Haweswater Aqueduct Resilience Programme, Marl Hill Section

**Ecology Comments on Planning Application 3/2021/0661
(Ribble Valley Borough Council)**

**John Jones
Senior Ecologist
Design & Construction Service
Lancashire County Council**

28th September 2021

FIGURE 6.5

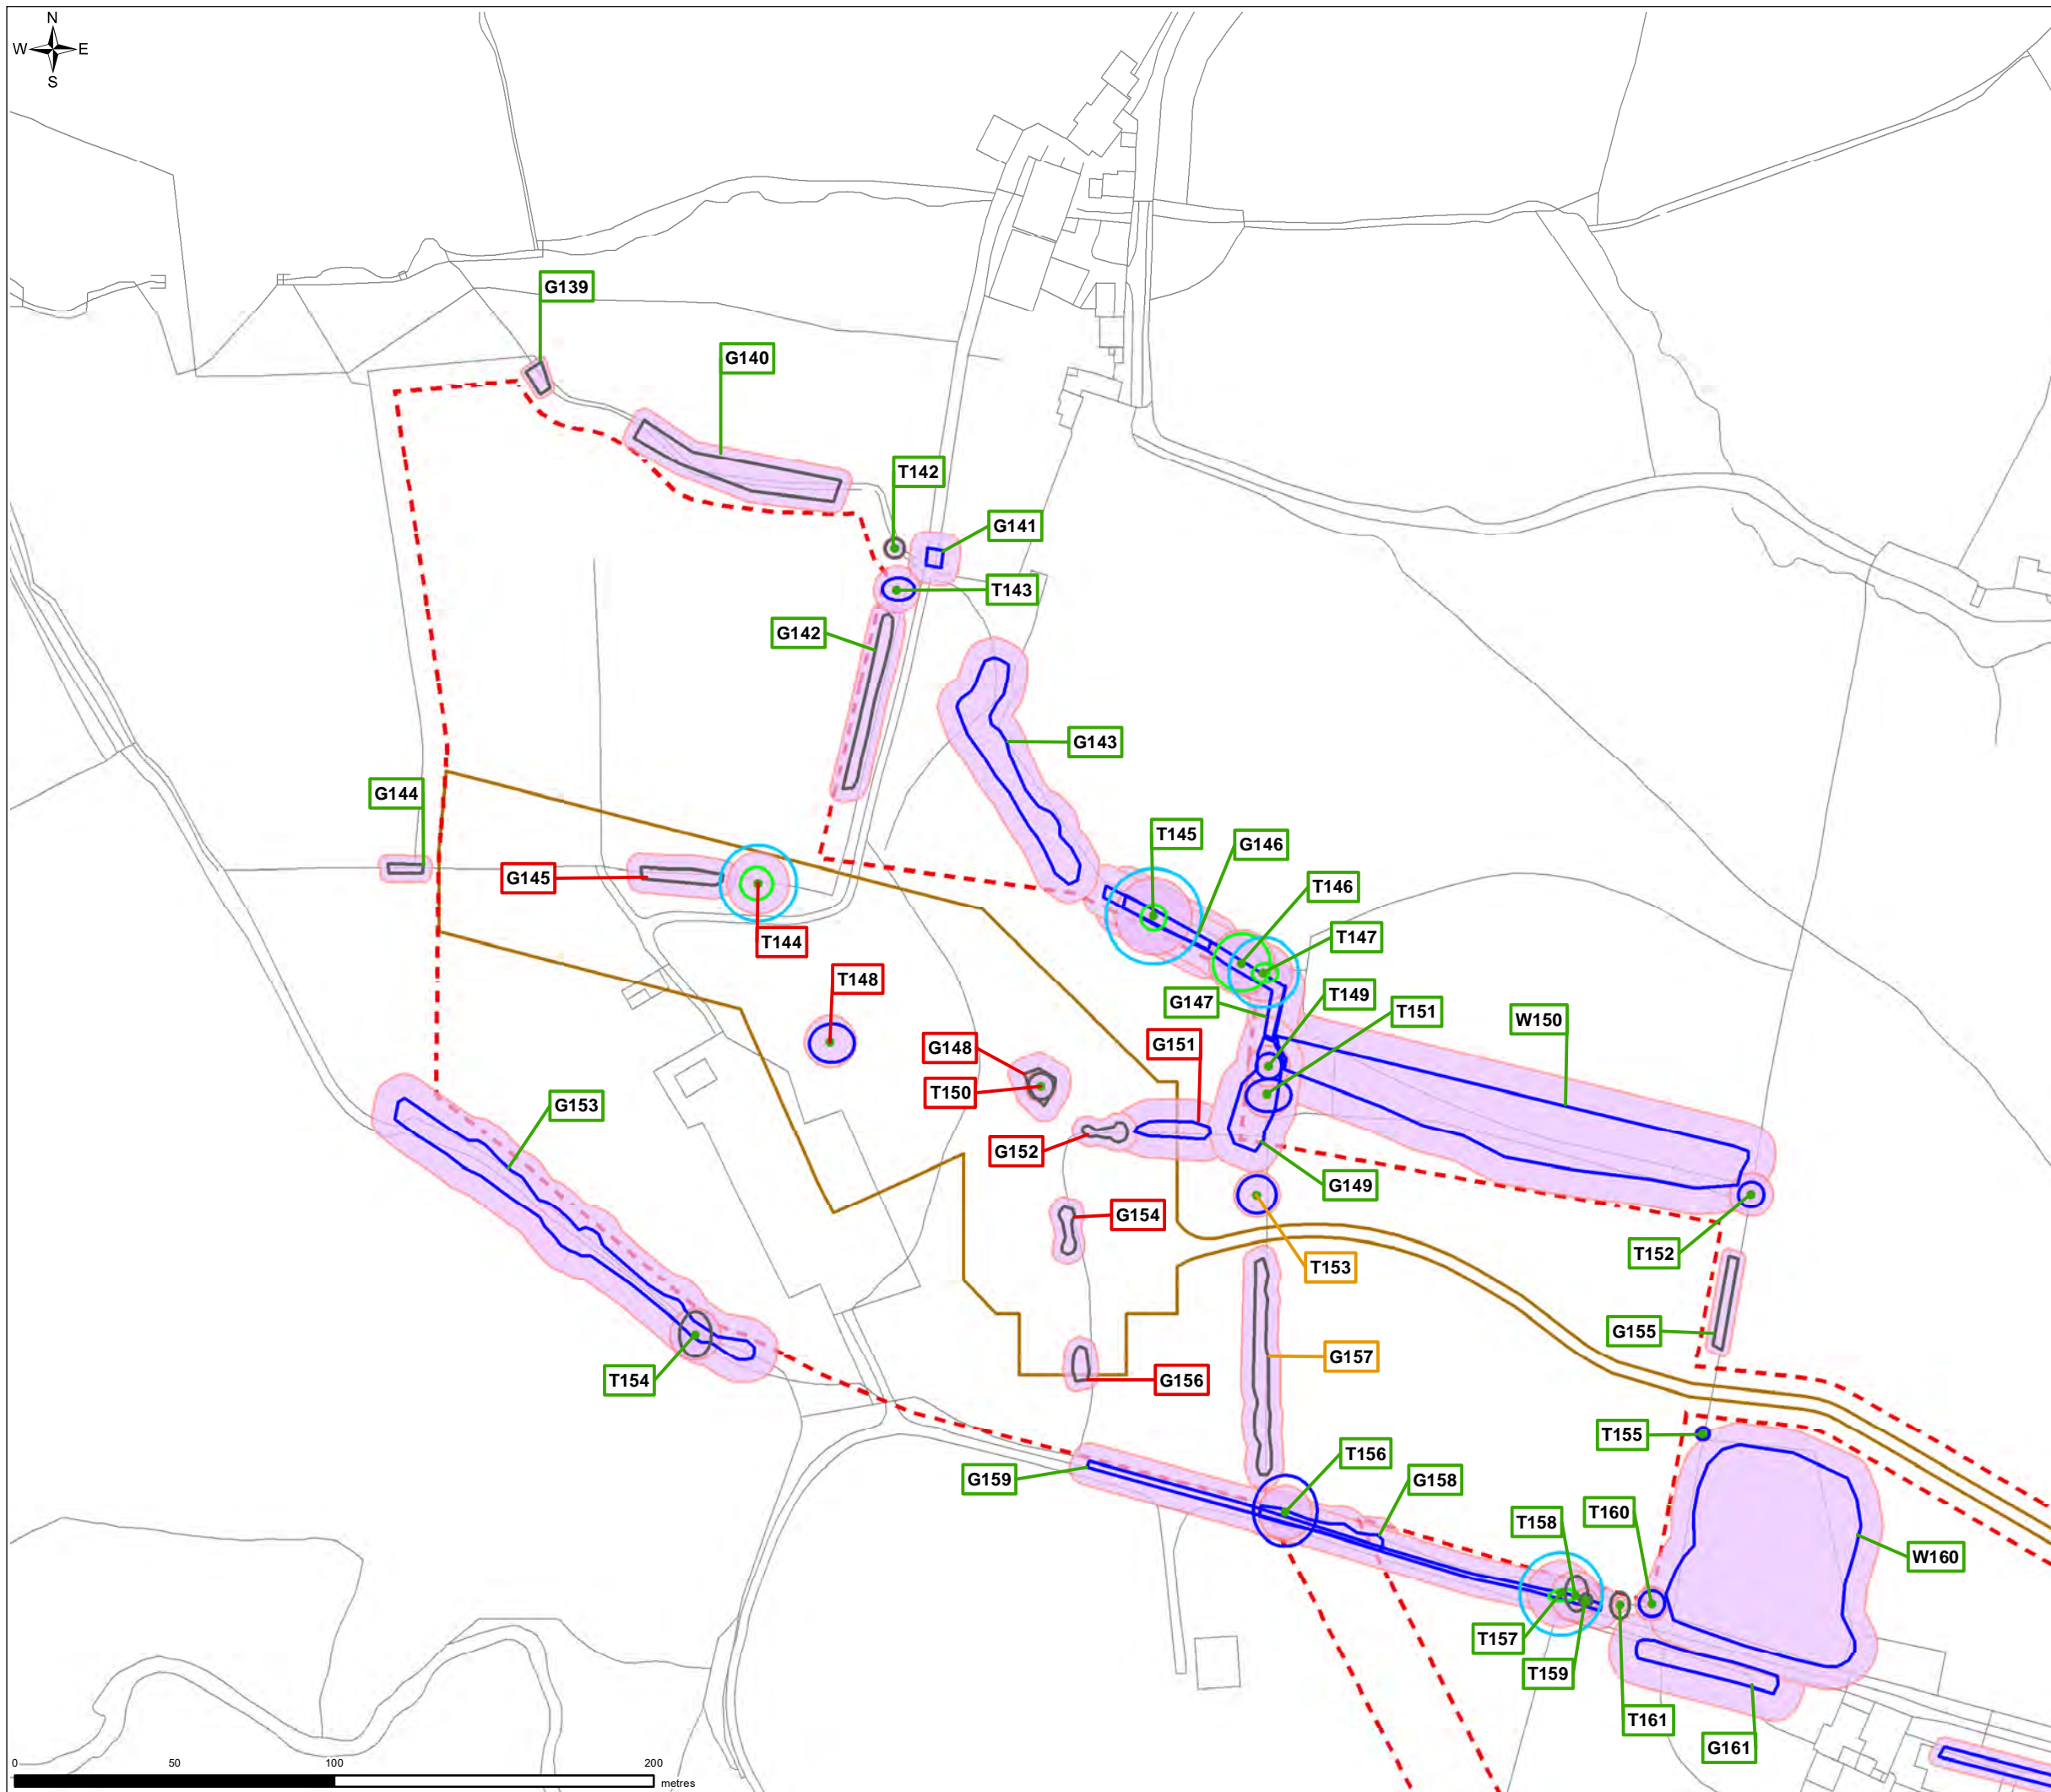
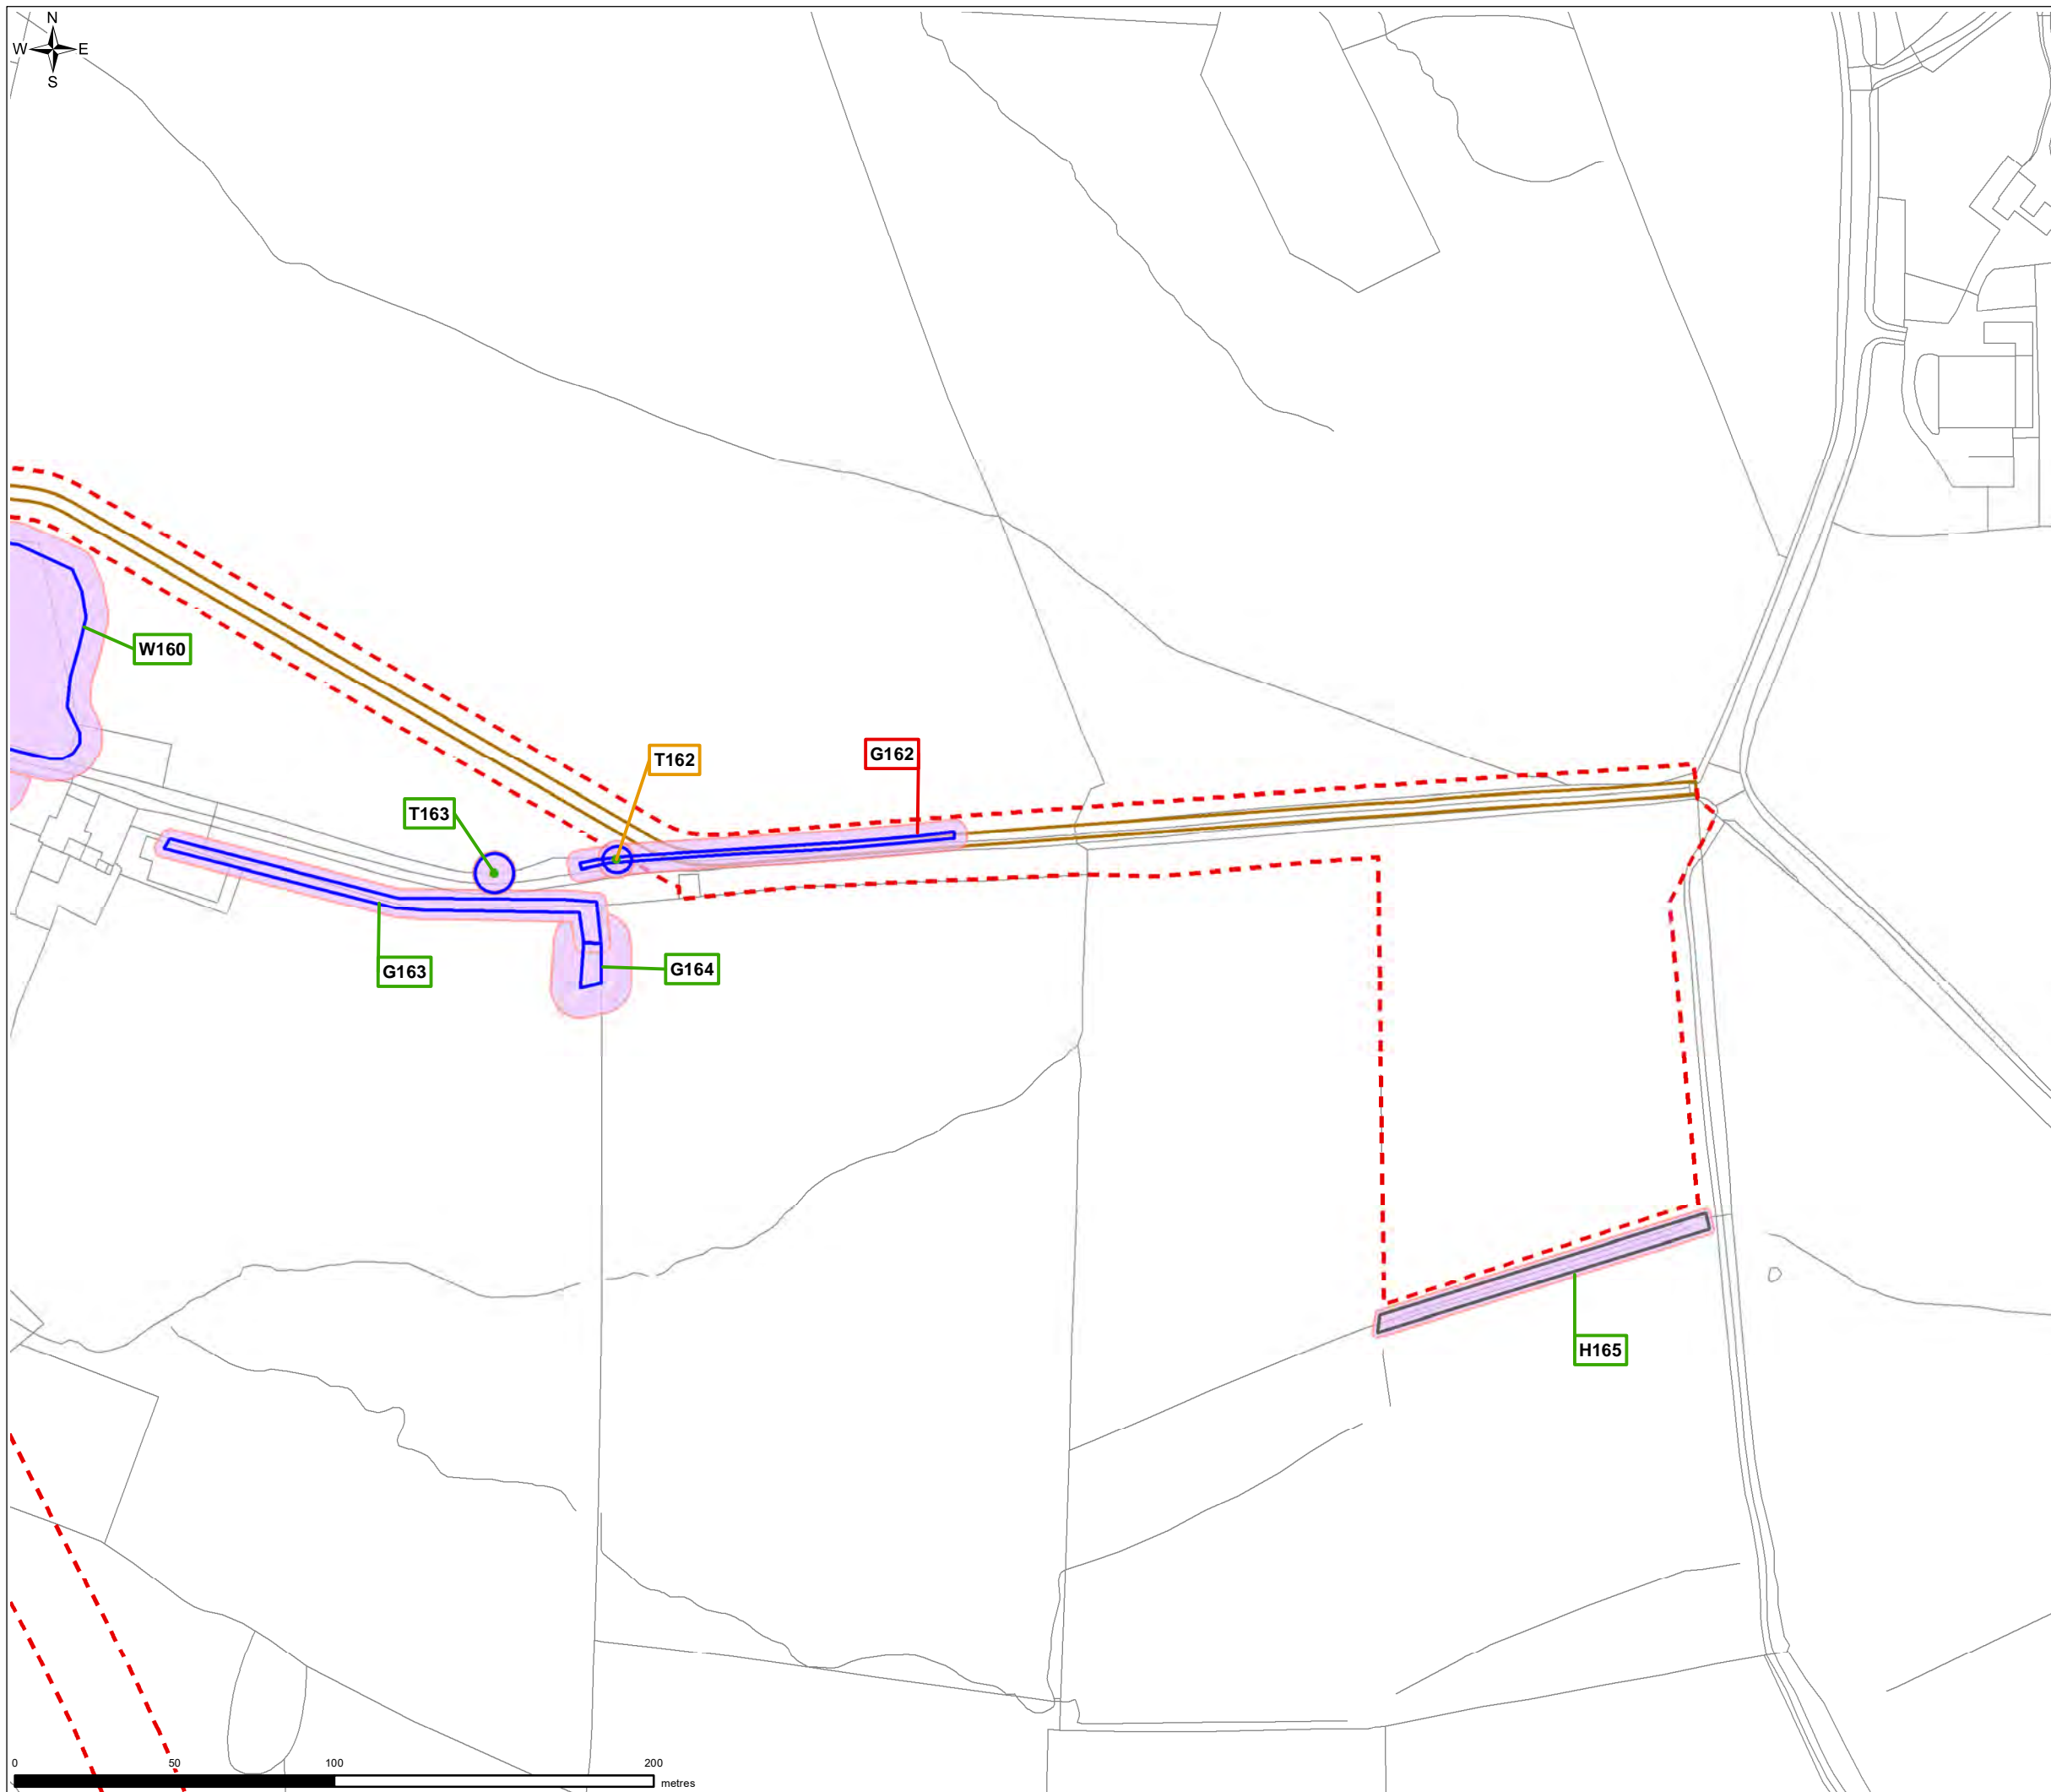
Within the scheme there are trees marked as at risk of removal. There also appear to be works proposed within the root protection area of trees shown as retained, which therefore may need to be removed. Consequently, there is uncertainty over the extent of impacts on potential bat roosting features. Certainty is required in order to inform the need for bat surveys and to enable the planning authority to consider the licensing tests prior to determination of the planning application. It should be clearly demonstrated that loss of features with the potential to support roosting bats has been minimised.
